From: Rael, Rudy E.
Sent: Thursday, September 08, 2016 2:55 PM
To: 'David Soule (david@riograndeengineering.com)'
Subject: 8009 Camino Alto NW

Based upon the information provided in your submittal received 8/26/16, the above referenced Grading and Drainage Report and plan cannot be approved for Grading Permit or Building Permit until the following comments are addressed:

ENGINEER'S SEAL 8/25/16 DAVID SOULE P.E. #14522	LOT 22 BLOCK 6 UNIT 22 VOLCANO CLIFFS SUBDIVISION	DRAWN BY JDG
	GRADING AND DRAINAGE PLAN	DATE 08-25-2016
 Rio Grande Engineering 1606 CENTRAL AVENUE SE SUITE 201 ALBUQUERQUE, NM 87106 (505) 872-0999	SHEET #	1 OF 1
	JOB #

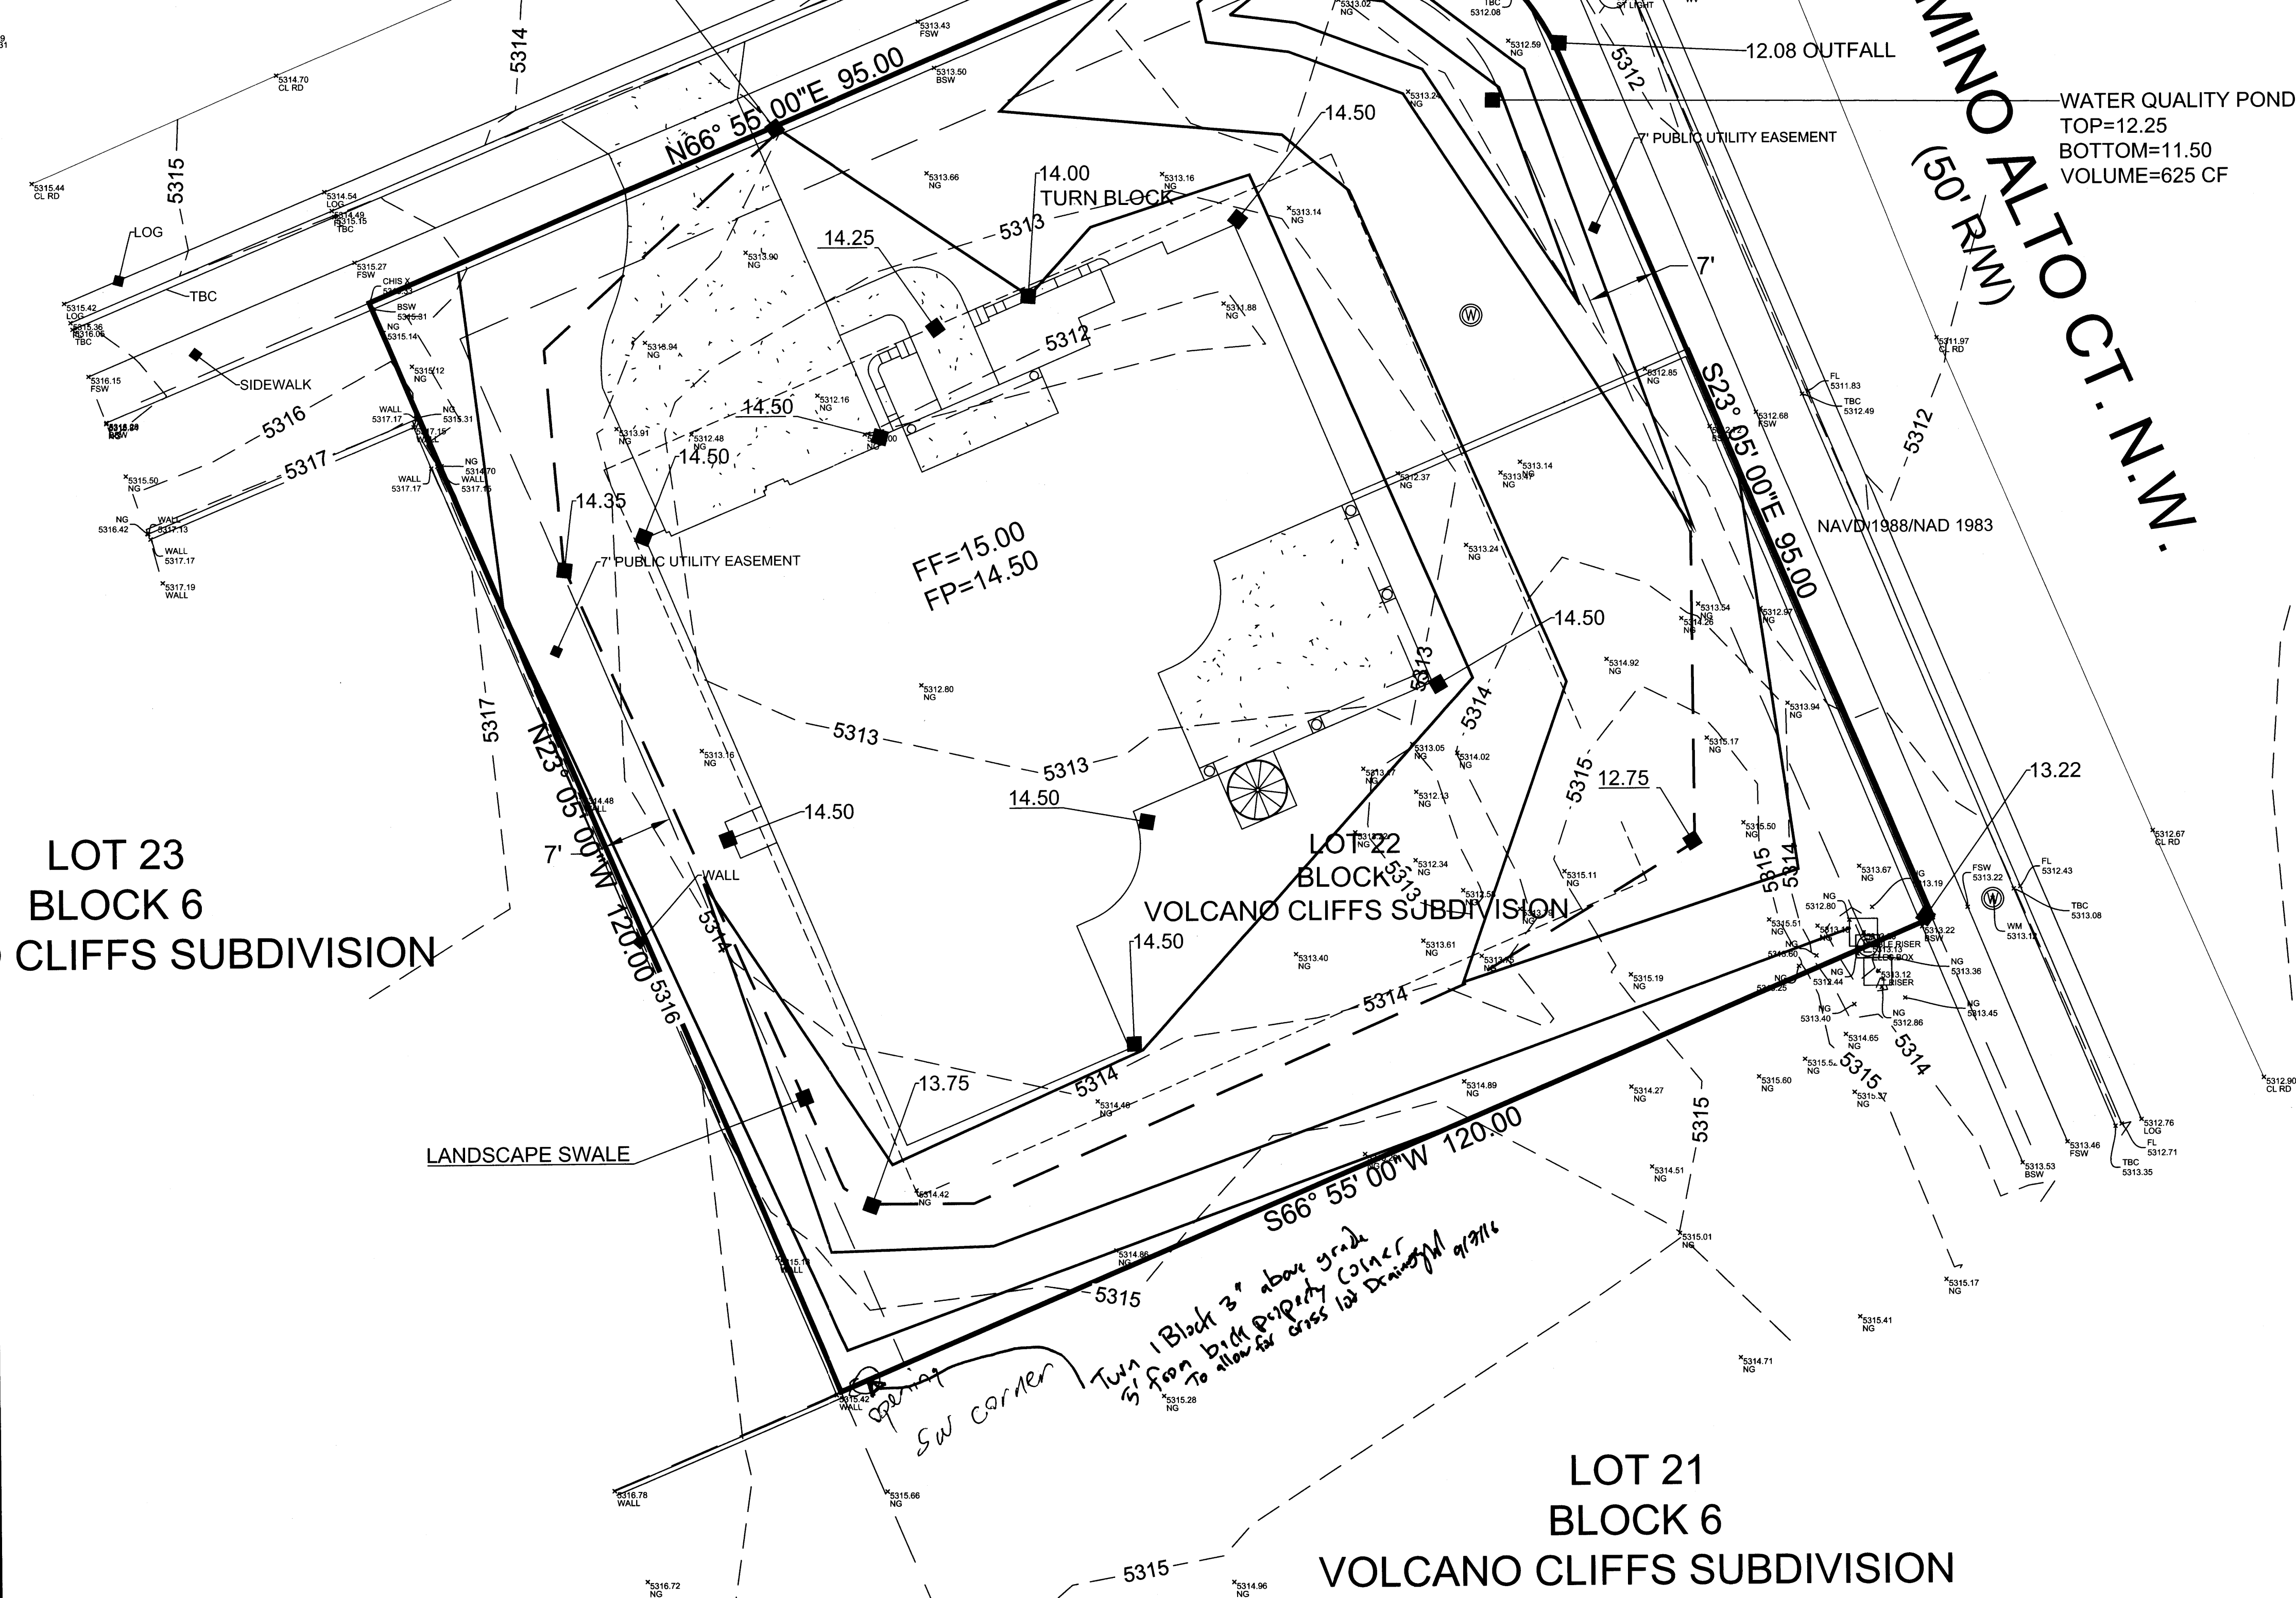
1. Provide a statement in the SW corner of the plan about an opening in a wall which is required for flows to enter from the south property.
2. Correct the city address on the DTIS, it shows 6308 Papagayo NW.
